From: Harriet Lobacz [REDACTED]
Sent: 08 September 2026 16:15
To: Simon Davis <Simon.Davis@arun.gov.uk>
Cc: Peter Cleveland [REDACTED] Lynn Pack [REDACTED] Sophie Robinson [REDACTED]
Subject: RE: WA/51/26/RES Arb Comments

Thank you for your comments regarding the Arboricultural Method Statement (AMS).

TREE PROTECTION PLAN: (12753 TPP 01 Rev A)

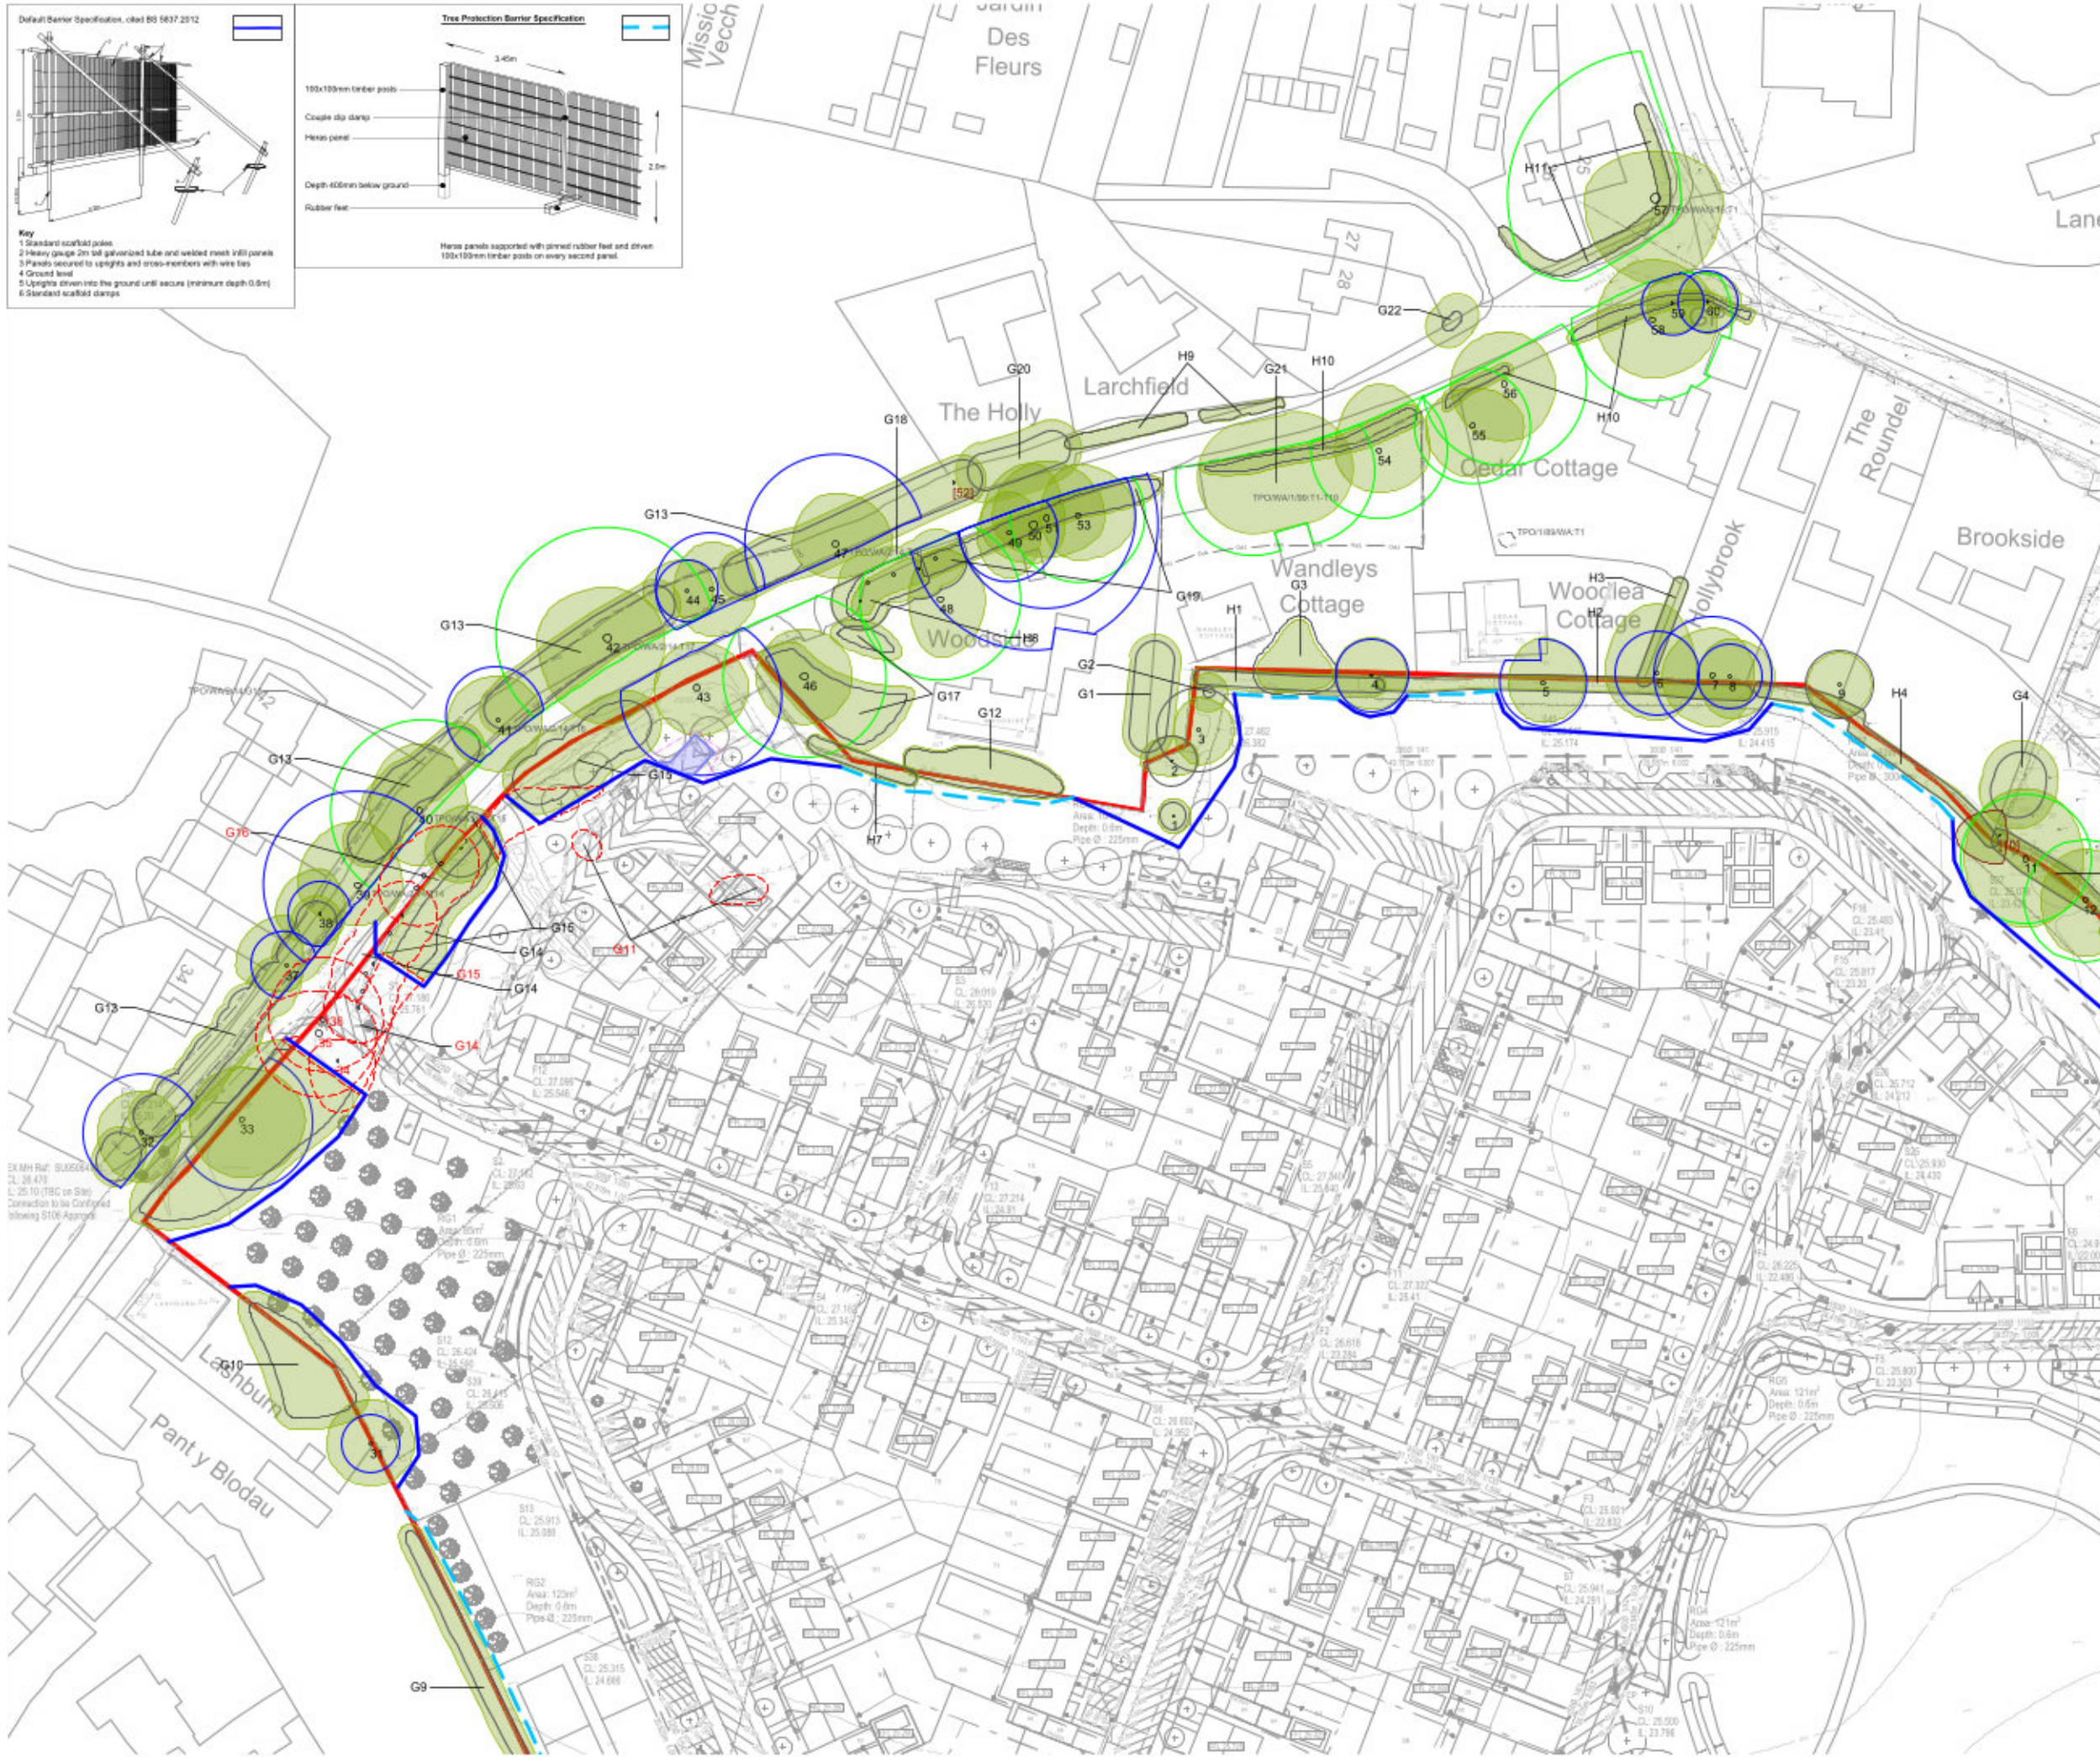
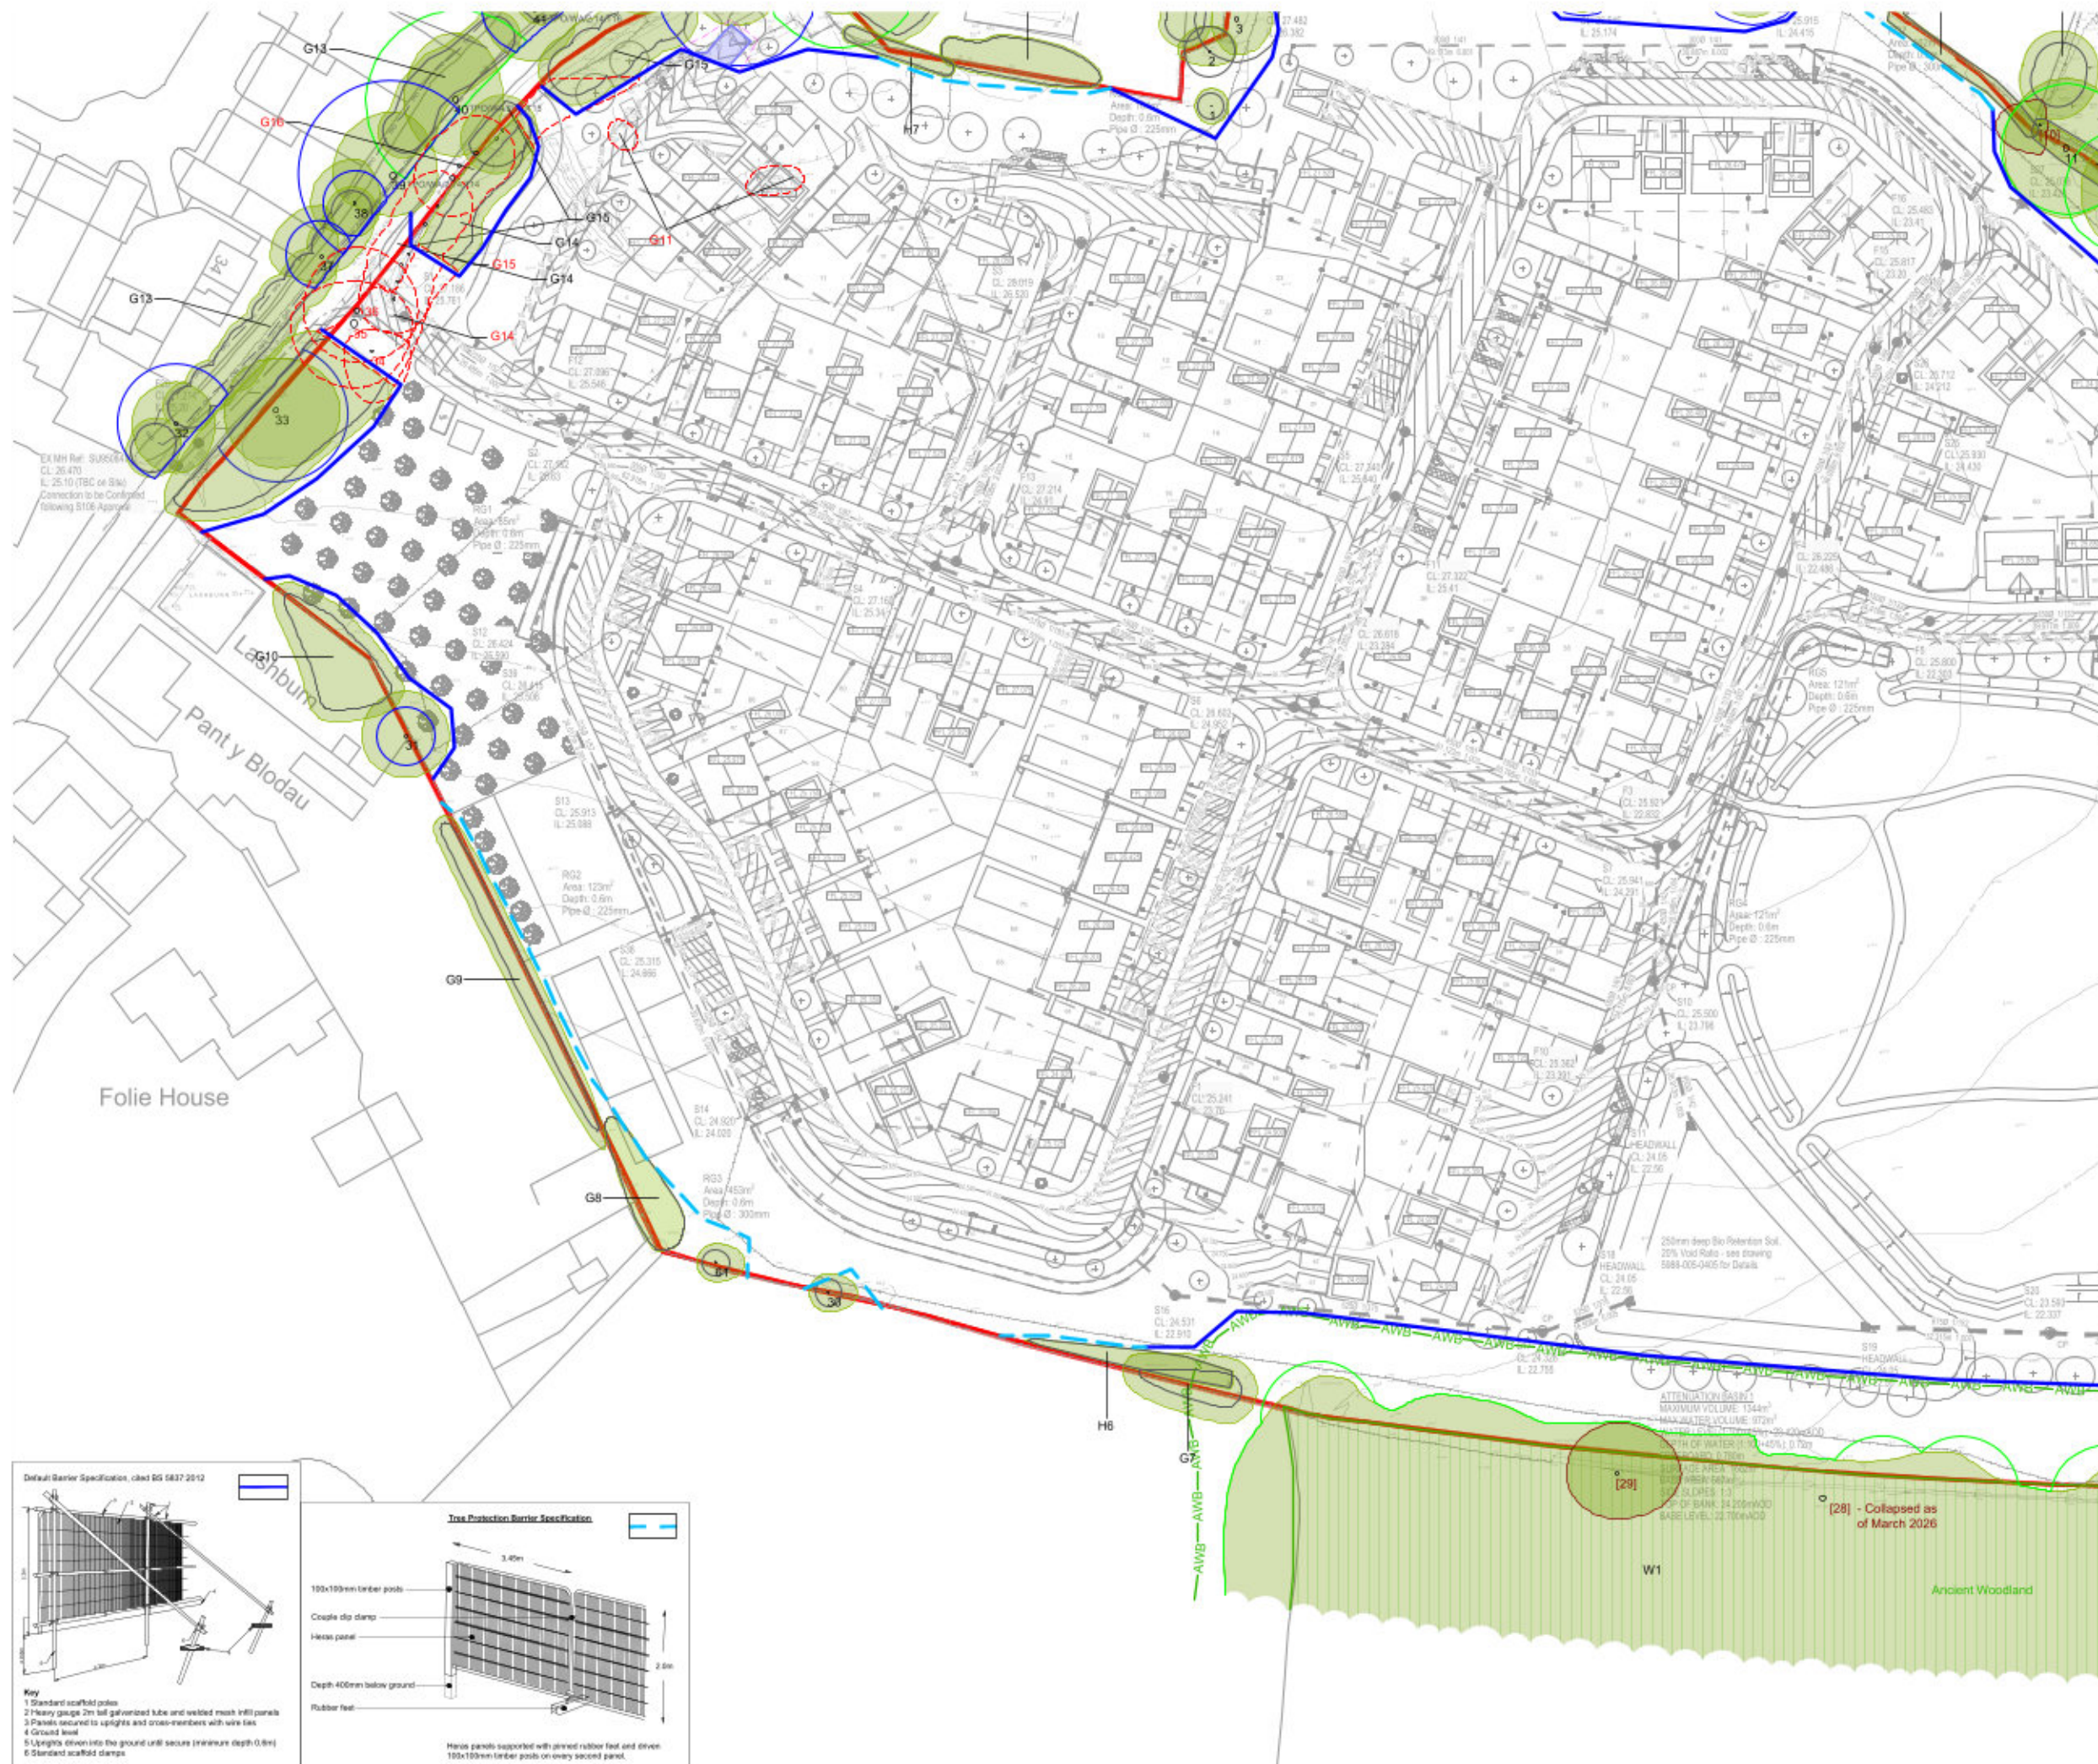
The AMS does not specifically discuss the Tree Preservation Order because the protected trees are unaffected by the proposed works. The relevant TPO trees are identified within the Tree Protection Plan and remain outside areas of impact. Equally, the high-value trees identified as T11, T12, T13, T17 and T20 have been afforded specific consideration throughout the design process. Indeed, the drainage layout was amended specifically to ensure that the final scheme avoids adverse impacts on these trees.

We also note the concerns raised regarding the relationship between the proposed SuDS infrastructure, the Ancient Woodland buffer and Root Protection Areas. The Ancient Woodland is afforded a minimum 15-metre buffer, with the nearest built development located approximately 18 metres away. This exceeds the buffer distance that was considered acceptable by the Inspector during the appeal. Whilst limited SuDS infrastructure is proposed at the edge of the buffer, it remains approximately 5 metres beyond the nearest Root Protection Areas. The Government guidance referenced within the Arboricultural comments acknowledges that appropriately designed infrastructure may be acceptable within buffer areas where root protection is maintained. The scheme has been designed on this basis and avoids encroachment into the relevant RPAs.
